**From:** Brenda Larsen  
**Sent:** Thursday, April 23, 2015 3:38 PM  
**To:** Jeff Watson  
**Subject:** Big Buck Ridge comment letter  
**Attachments:** Big Buck Ridge.doc

Re: Big Buck Ridge Cluster Plat (LP-07-00040)

*Fire Marshal*  
*509-962-7000*

PROJECT#	SHEET: 2
2007-389	OF: 3

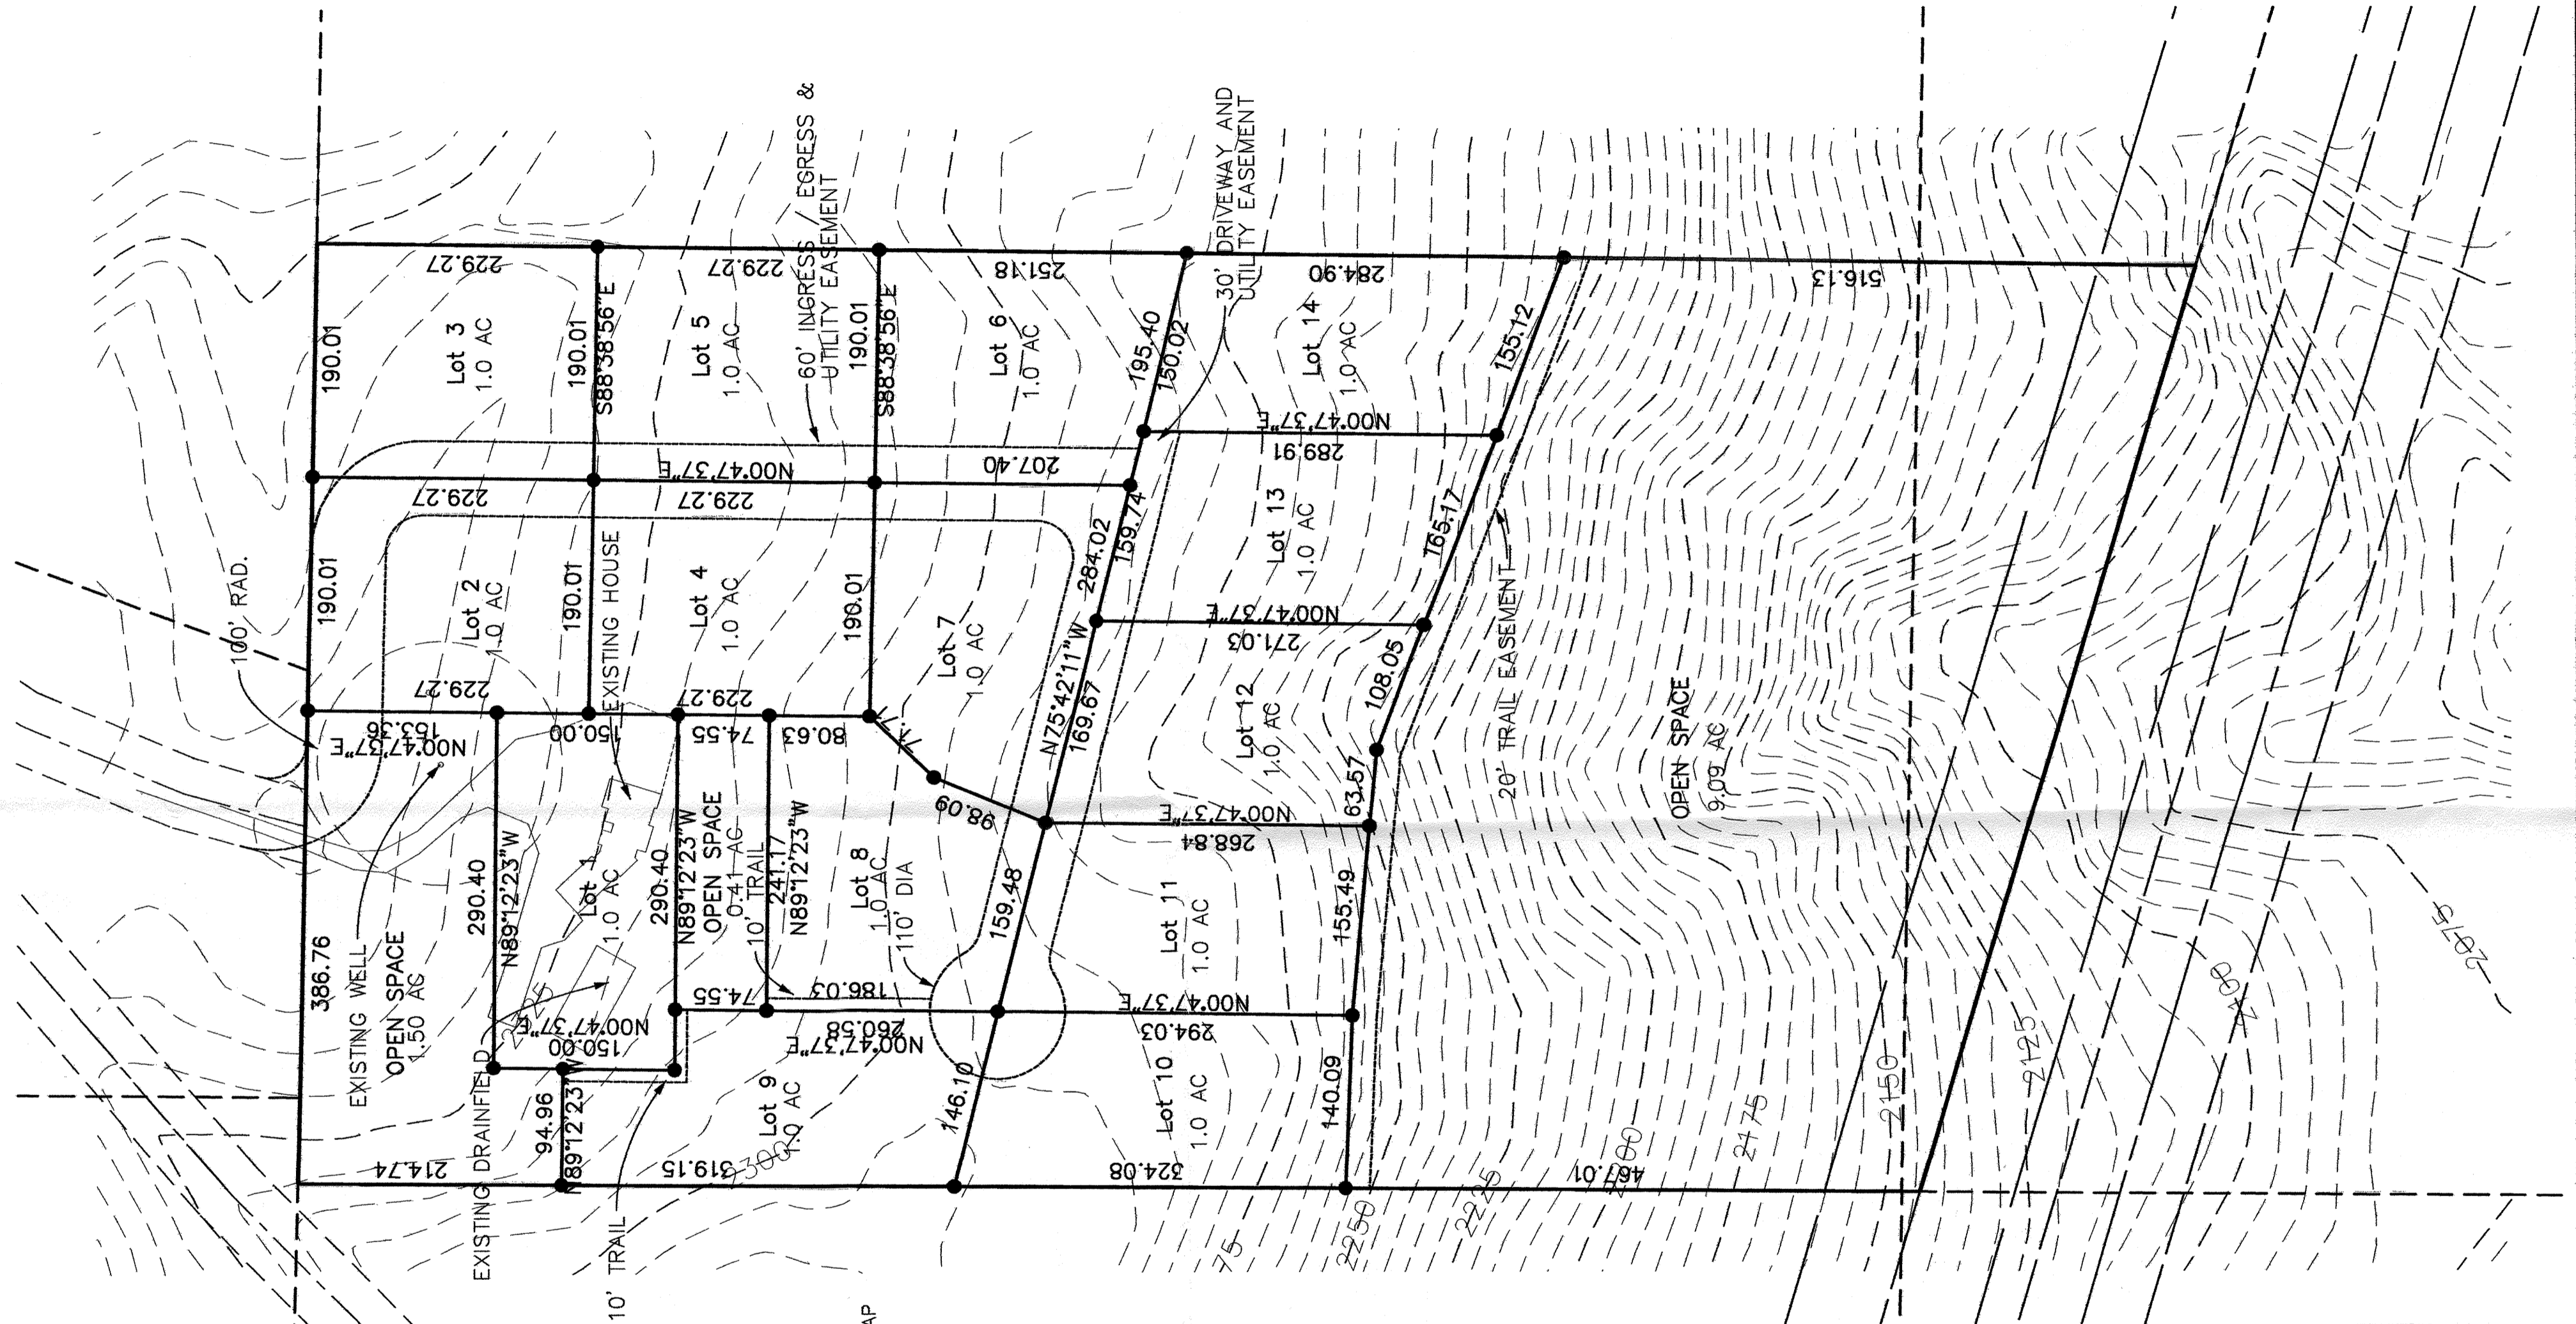
- Approved water storage of 15,000 gallons, with a private fire hydrant system shall be installed.
- Water storage and hydrant spacing shall comply with the International Fire Code.

- No fire apparatus access lane shall have a slope greater than 12%. A Variance Permit will be required for any slopes or grades greater than allowed by County Code.

- "No Parking-Fire Lane" signs must be posted per Fire Marshal requirements on any cul-de-sacs.
- All development, design and construction shall comply with Kittitas County Code, Kittitas County Zoning and the 2012 International Fire and Building Codes.

- A separate permit is required for any private water storage or hydrant system. The tank and hydrant system shall be subject to plan review through the Fire Marshal's Office and shall be subject to an annual Operational Permit.
